**DELEGATED DECISION FOR APPLICATION FOR CERTIFICATE OF
LAWFUL DEVELOPMENT**

Reference no.: 2026/CL/91289/W

Site: 43, Woodlea Avenue, Marsh, Huddersfield, HD3
4EF

Description: Certificate of lawfulness for proposed erection of
single storey rear extension and associated alterations

Scale: 1:50 & 1:100	Drawing Number 2026/019/03	Rev. Rev.	Date Drawn May 2026	Drawn By Andrew Smith
------------------------	-------------------------------	--------------	------------------------	--------------------------

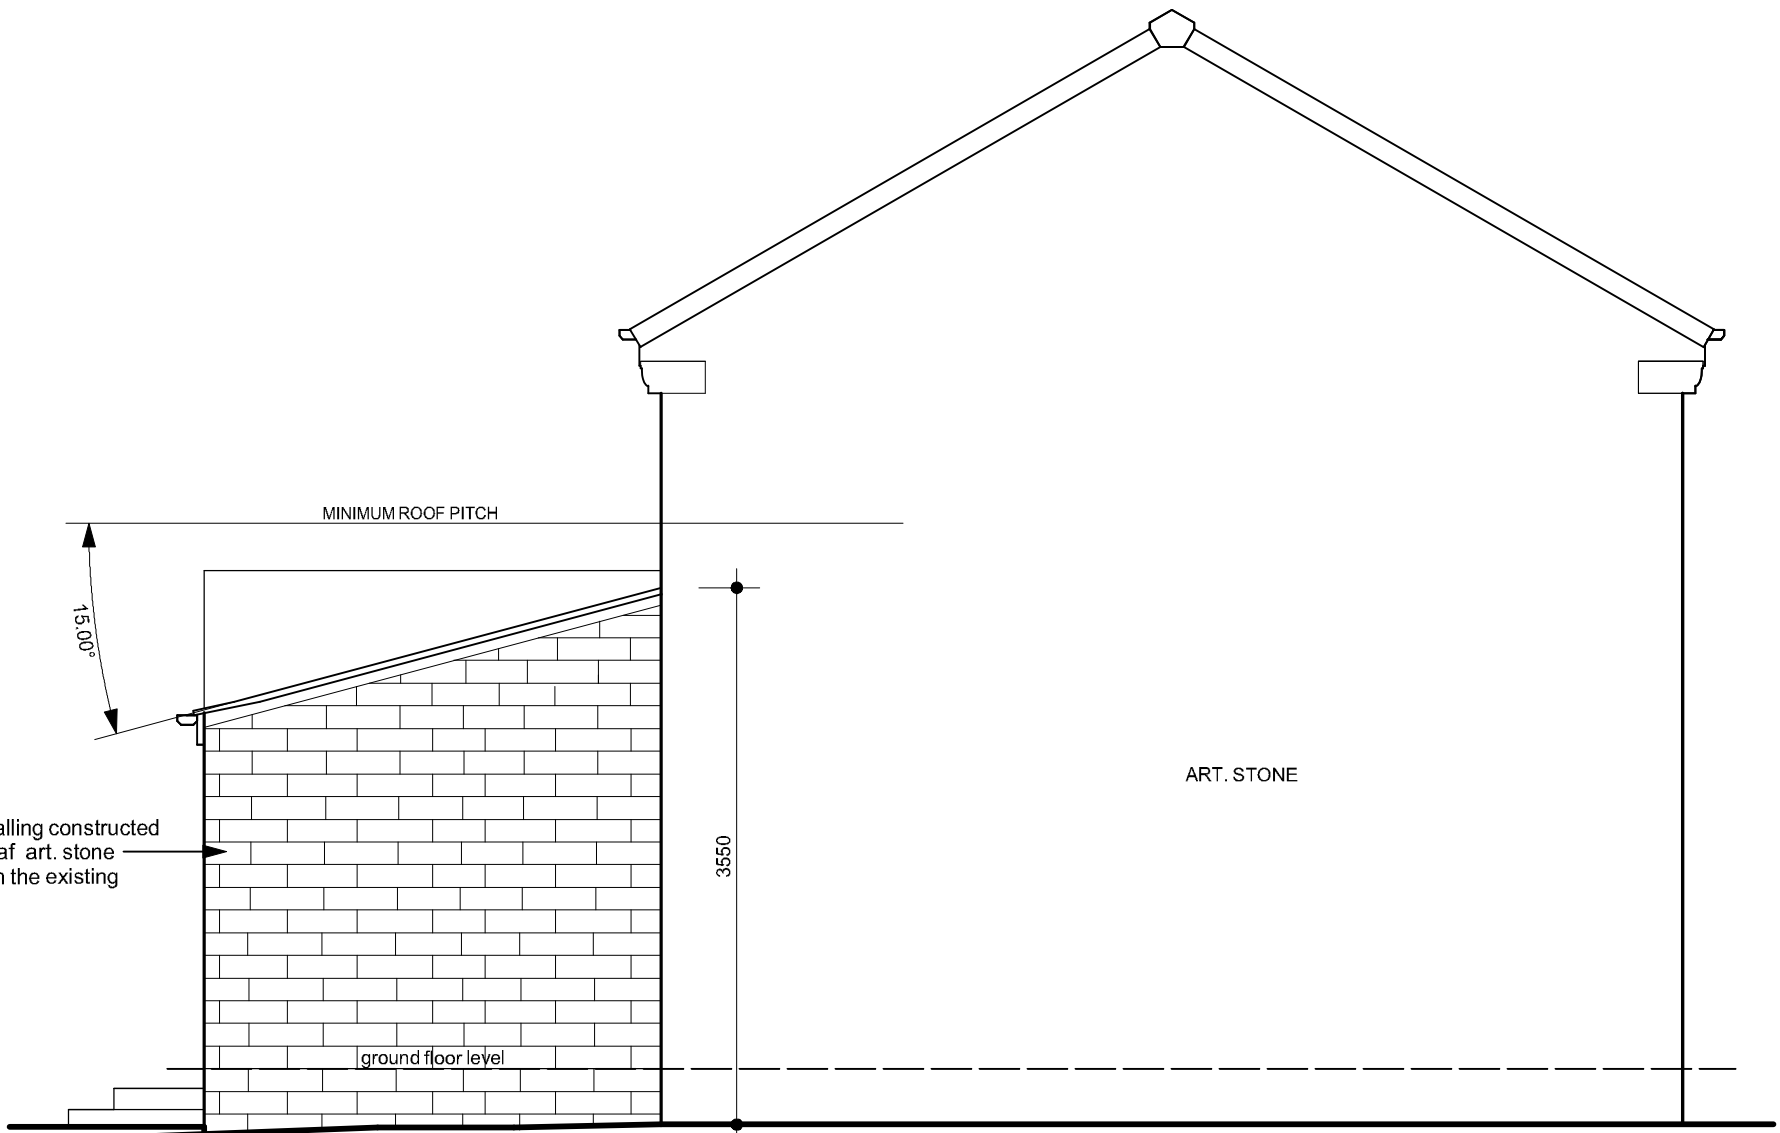
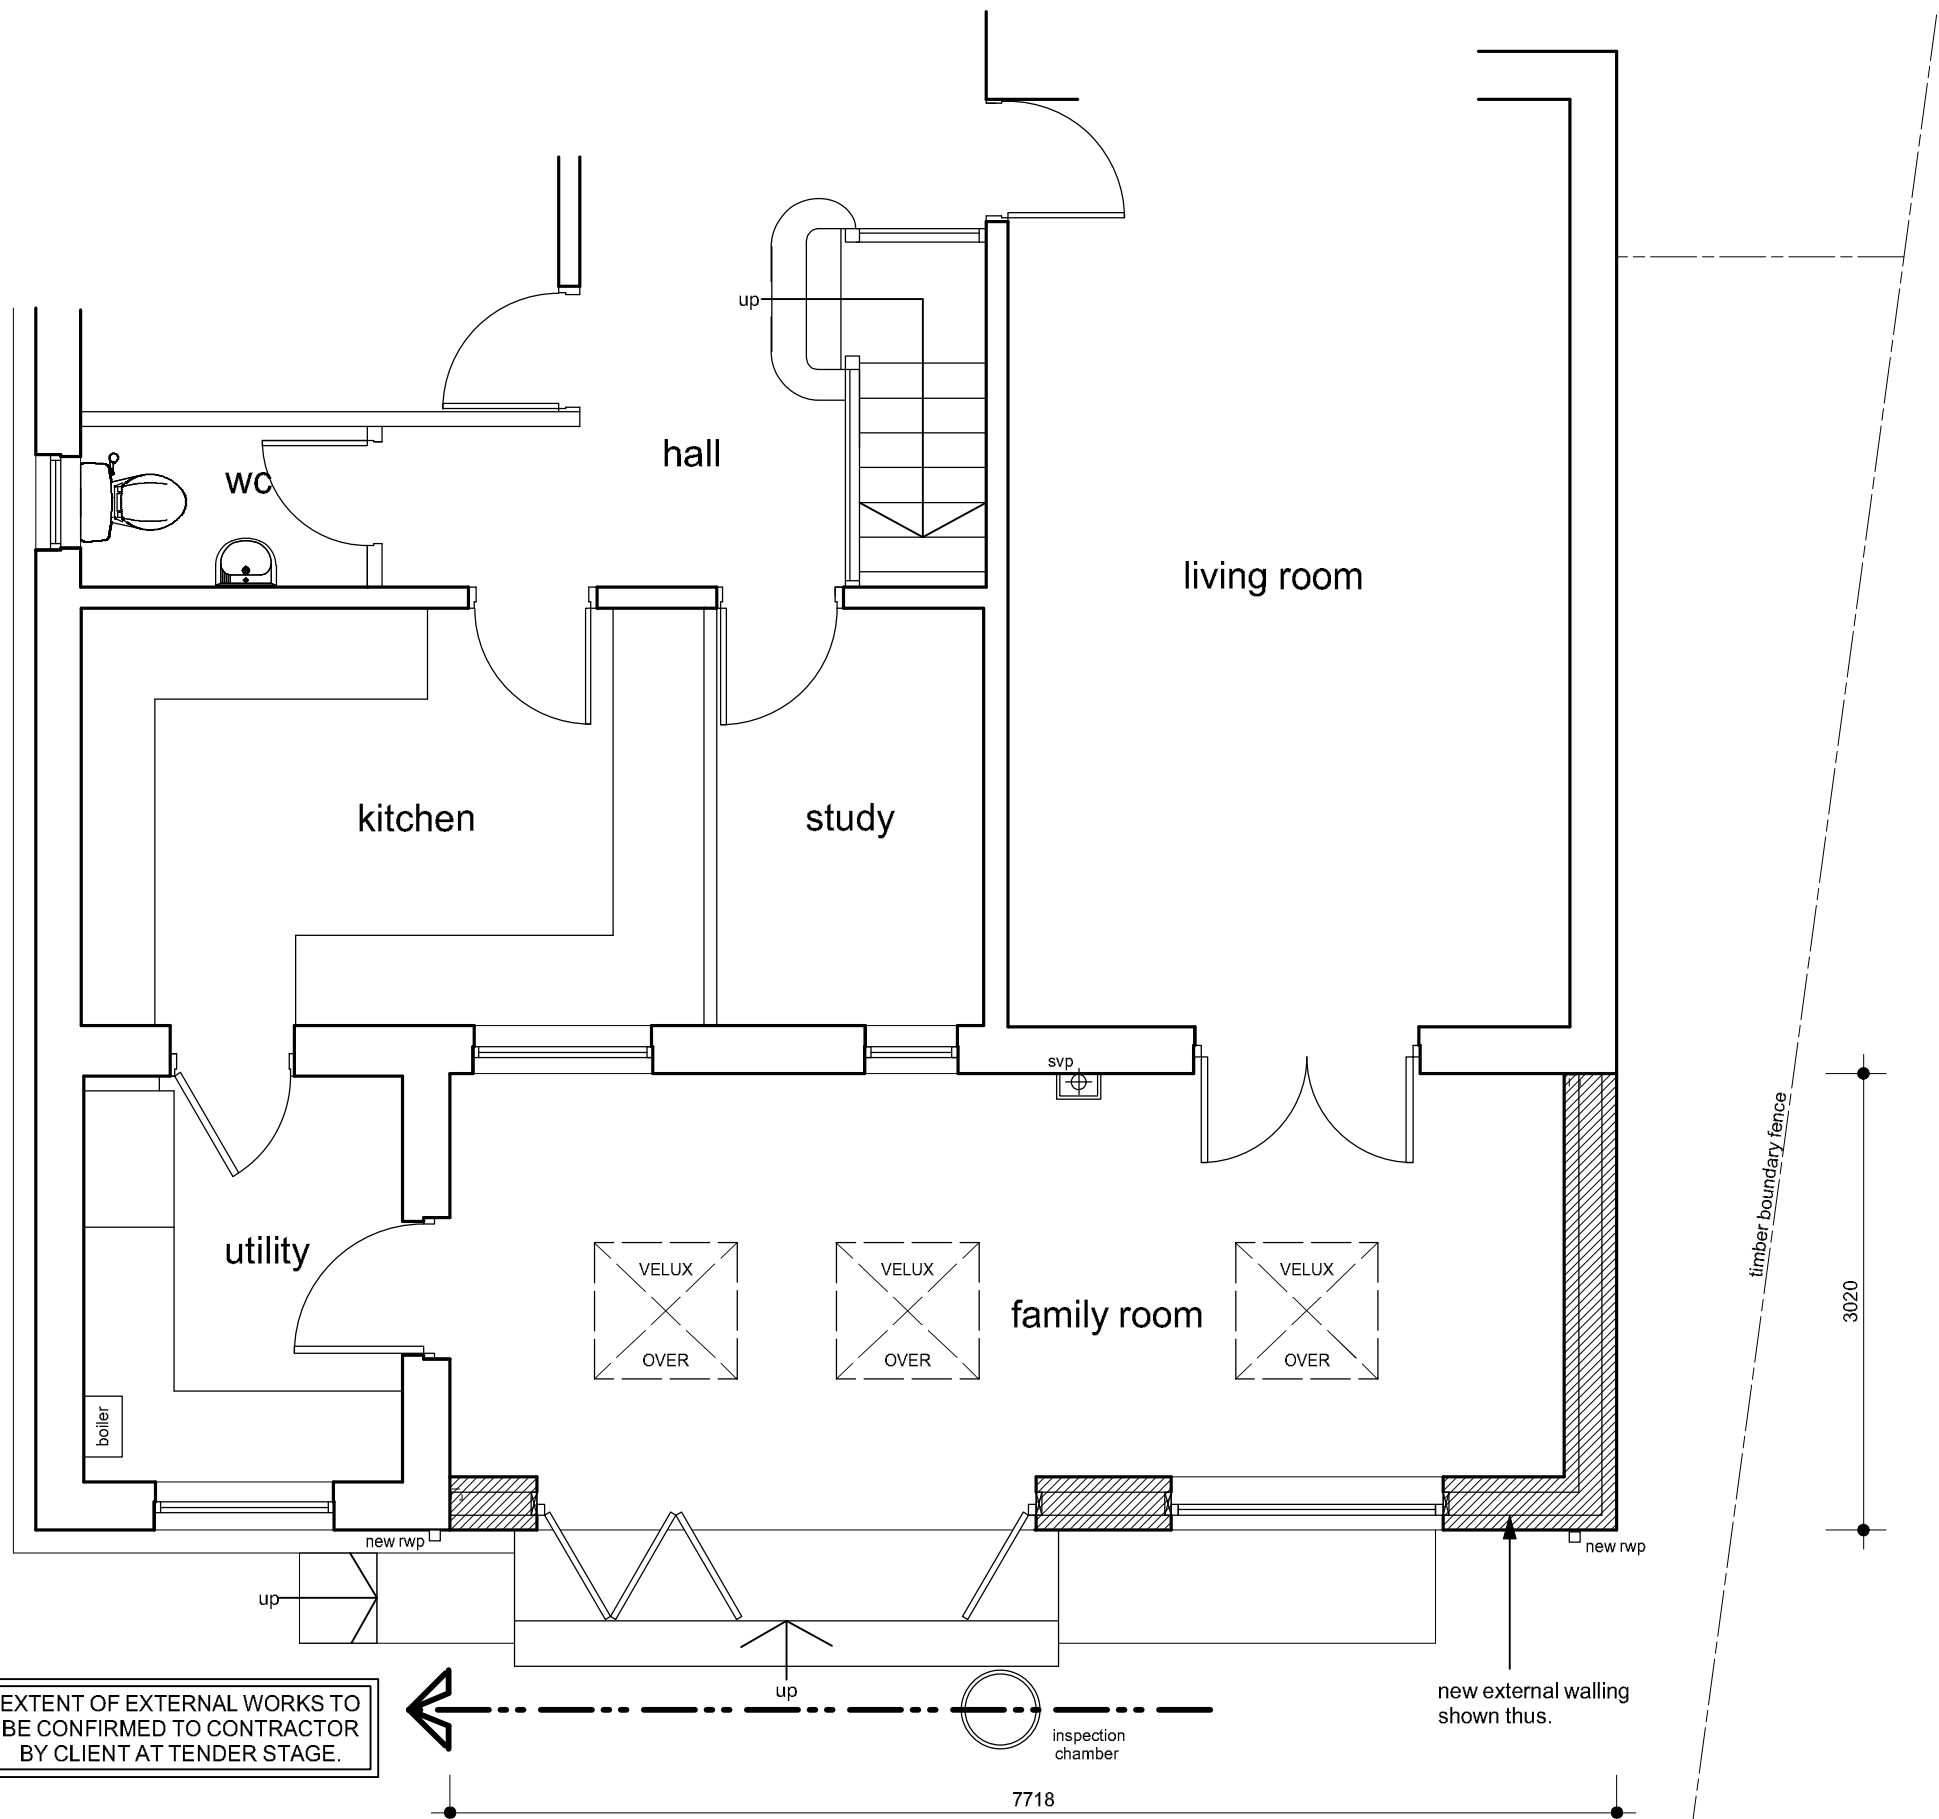
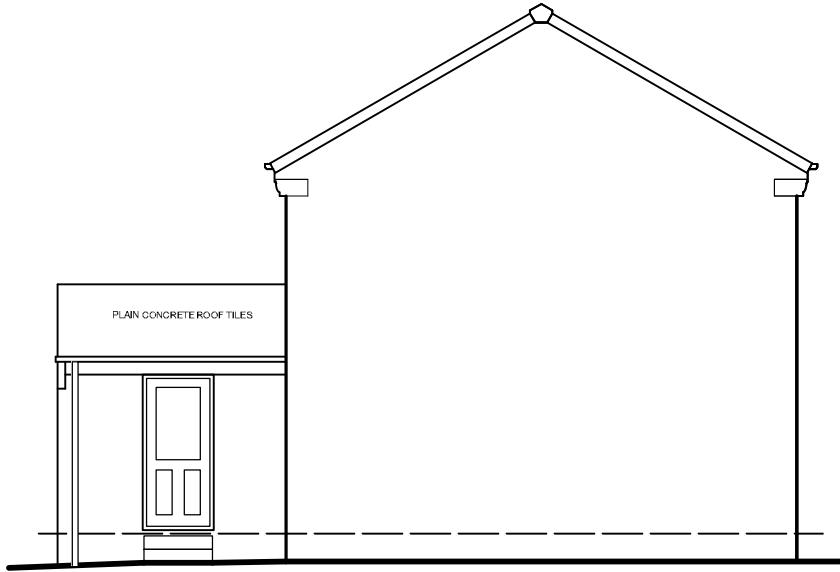
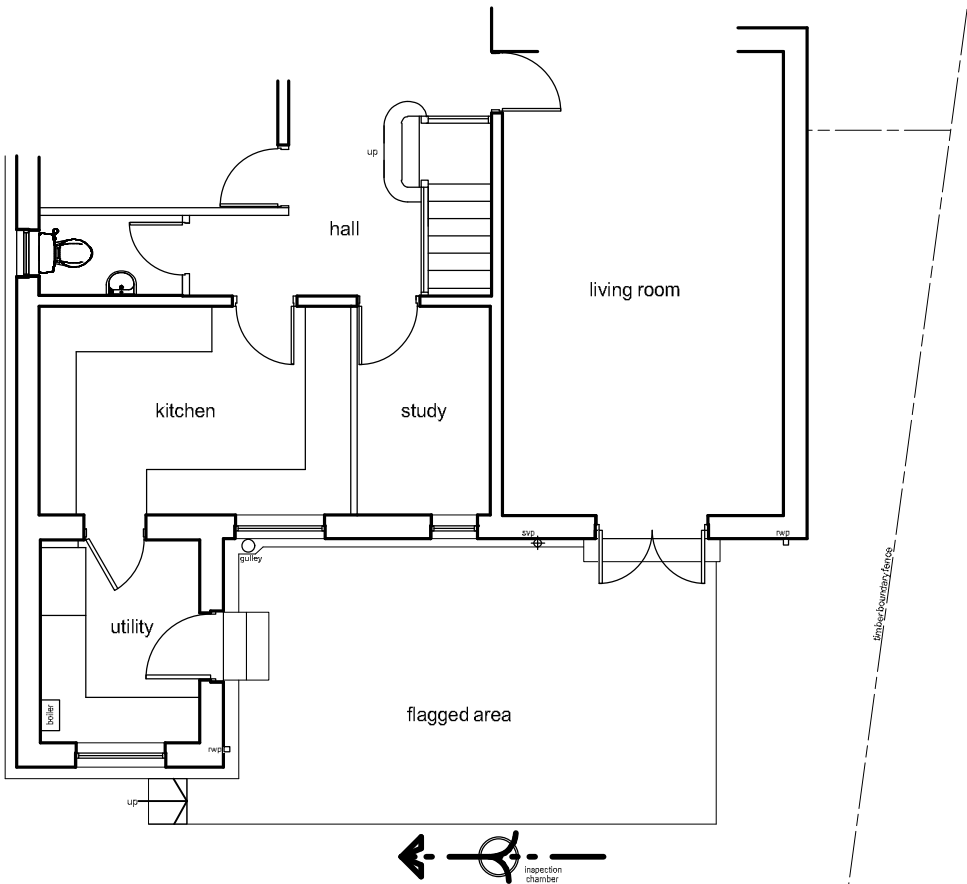
Comment: *The rearward projection is an original feature as it is evident on the proposed site plan of the 1996/03433 approved drawing. Therefore, as demonstrated on page 22 of the Permitted development rights for householders – Technical Guidance document, the enlargements would also*

be deemed side extensions. The enlargements would not exceed 4 metres in height, would not have more than a single storey, however, when measured alongside the original feature the structure would be more than half the width of the original dwellinghouse. The Technical Guidance is clear on page 23 that 'if the proposed extension creates a total enlargement which has a width greater than half the width of the original dwellinghouse, it would not be permitted development.' The proposal therefore fails to comply with this requirement.

The development does not benefit from a general planning permission under Article 3(1) and Schedule 2, Part 1, Class A of the Town and Country Planning (General Permitted Development) (England) Order 2015 (as amended) as the proposed enlargement would extend beyond a wall forming the side elevation of the original dwellinghouse and would have a width more than half the width of the original dwellinghouse contrary to sub-paragraph A.1 (j) (iii) of Class A.
